MEMORANDUM

PROJECT: SCEGGS
JOB NO.: 160441

SUBJECT SCEGGS DARINGHURST SSD-8993 – REQUEST FOR ADDITIONAL INFORMATION

The NSW Department of Planning requested additional information in relation to SCEGGS Darlinghurst Concept and Stage 1 (SSD-8993) in letter dated 19/12/19.

Drawing No.
AR.MP.2108

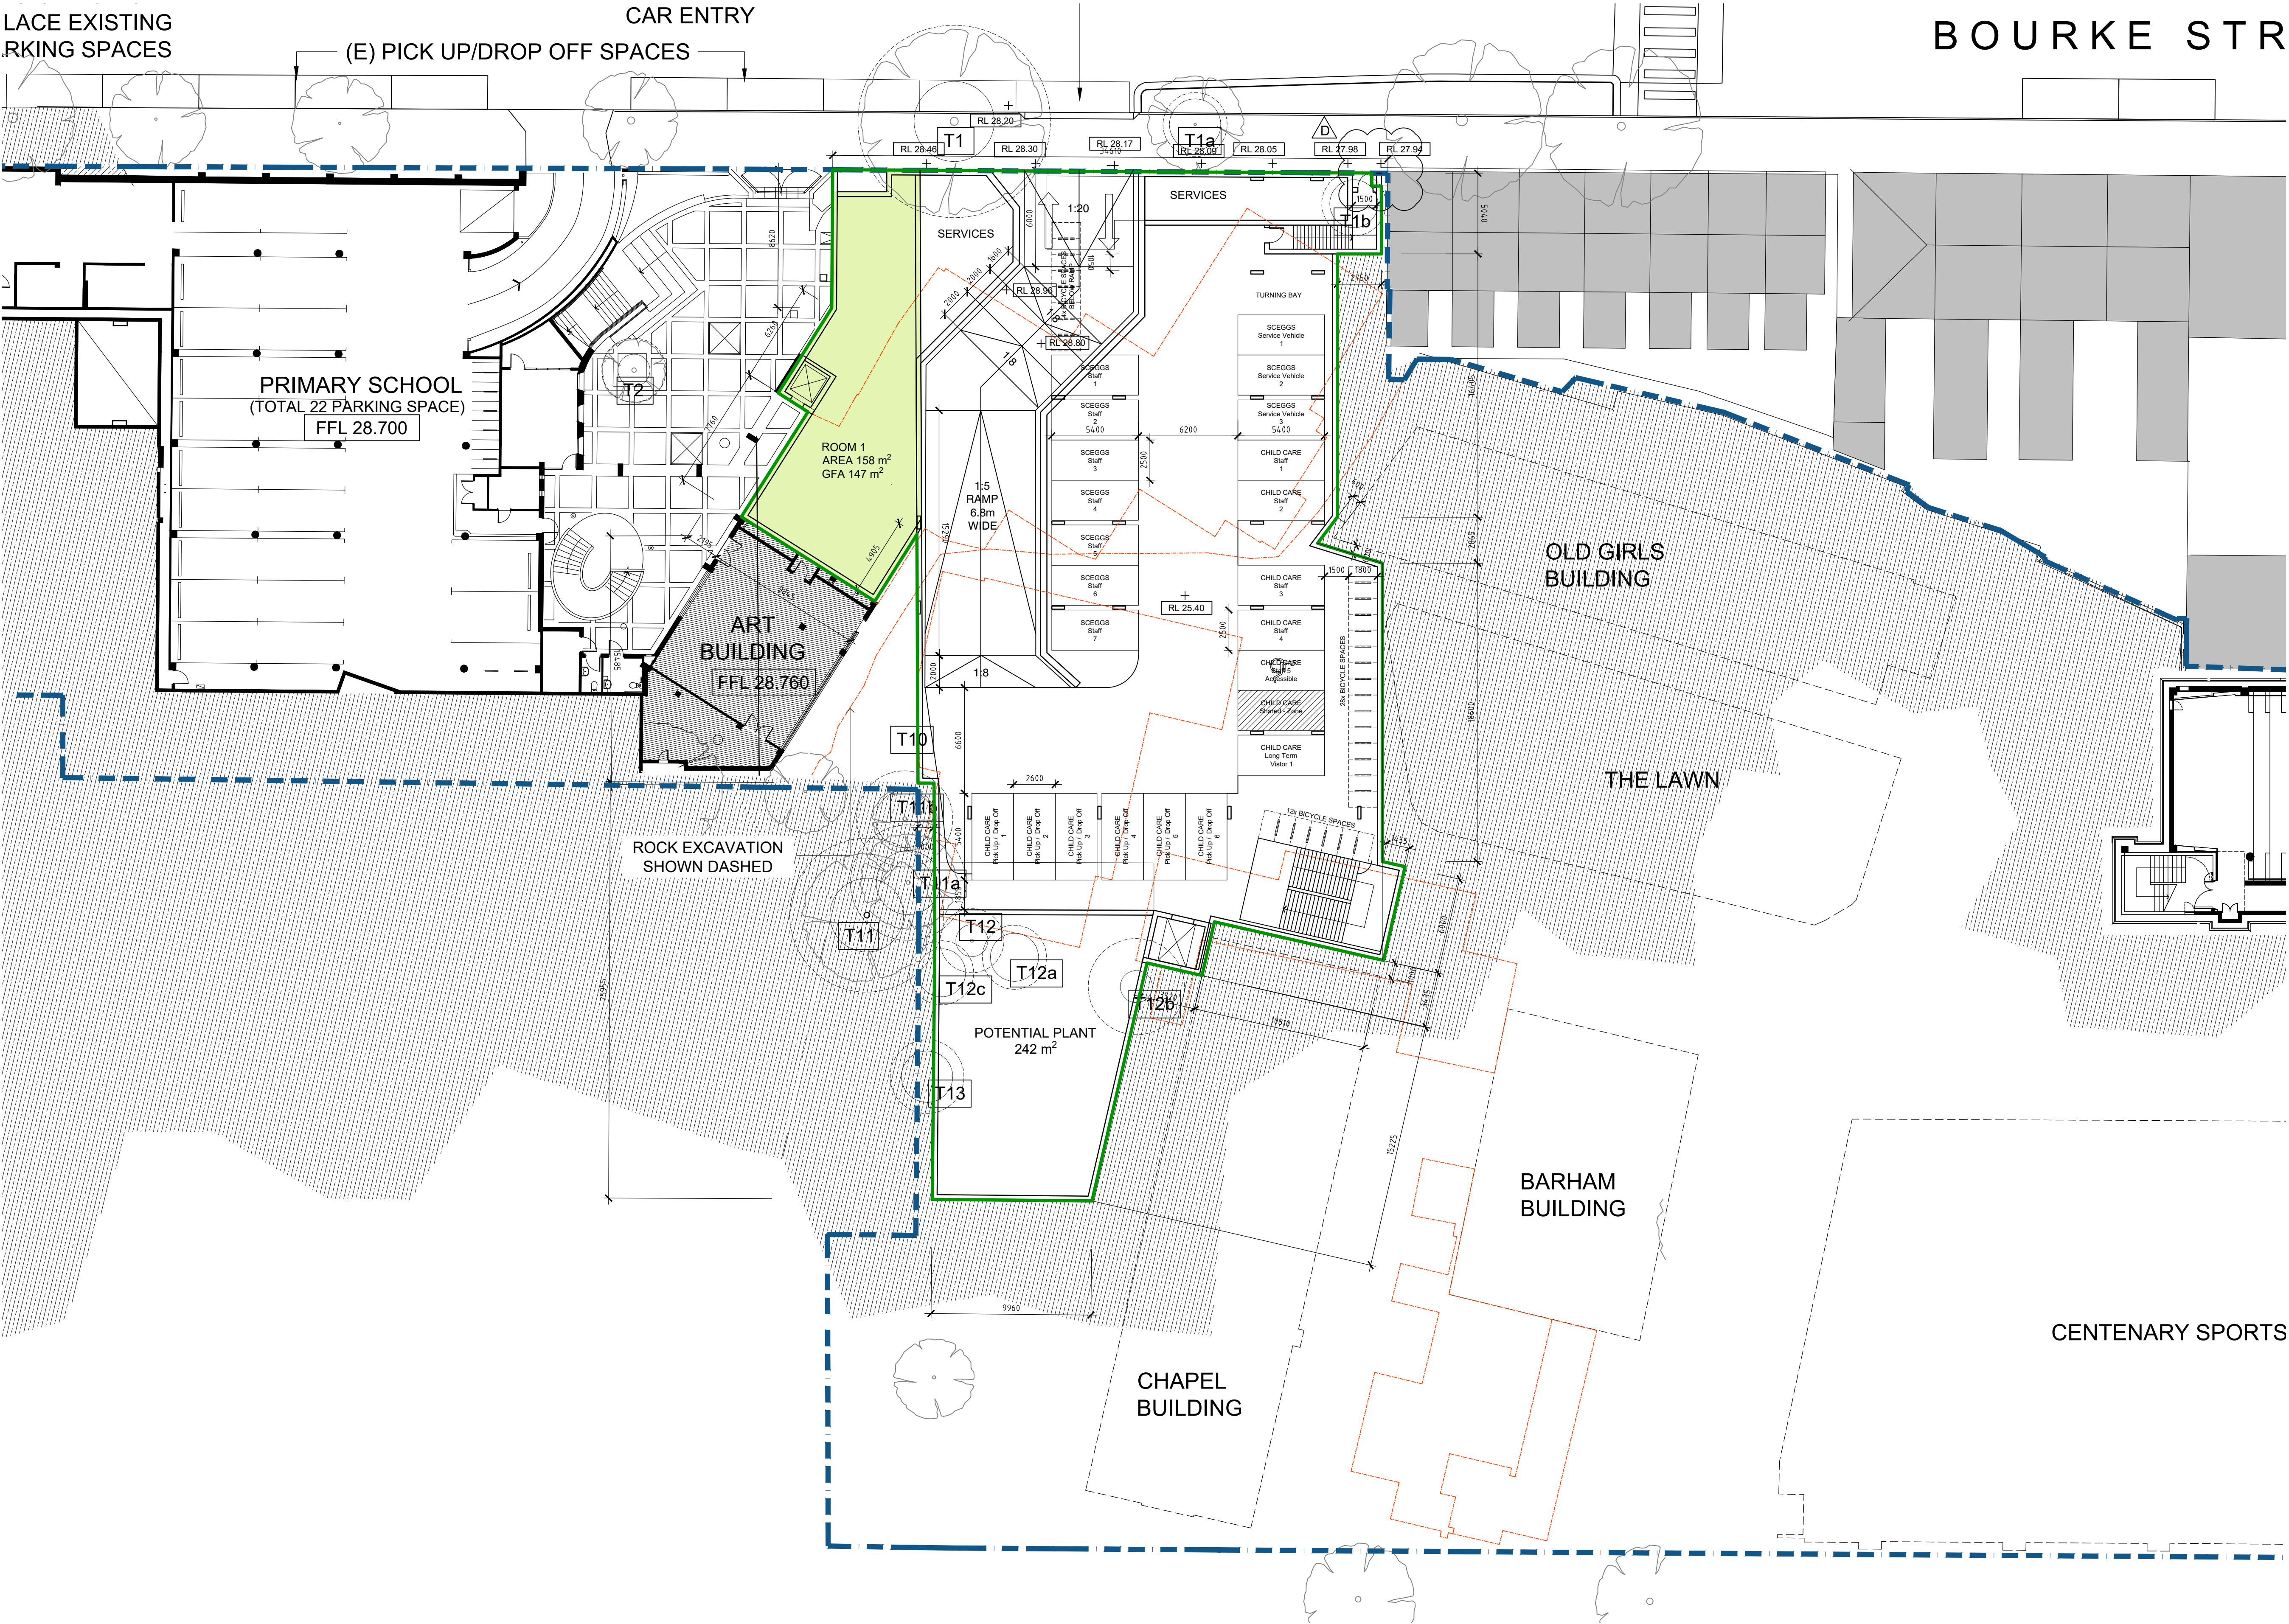
Request for Additional Information	Response
<p>Interface with Bourke Street terraces</p> <p>The recess shown in the detailed drawings (eg AR.MP.6003) between the heritage terraces and the proposed two storey street wall is not reflected in the proposed building envelope. The envelope should reflect the plans with the depth of the recess to be at least 1 metre from the face of the proposed new building to Bourke Street. The height of this indented recess is to also be amended in the envelope to reflect the detailed architectural drawings.</p>	<p>The envelope drawings have been amended to include a 1m wide indented recess adjacent to the existing terrace house on Bourke Street.</p> <p>The following drawings have been amended:</p> <ul style="list-style-type: none">- AR.MP.1102, Rev D- AR.MP.2101, Rev E- AR.MP.2102, Rev D- AR.MP.2108, Rev D- AR.MP.2109, Rev D- AR.MP.2110, Rev D- AR.MP.2111, Rev D- AR.MP.3002, Rev D
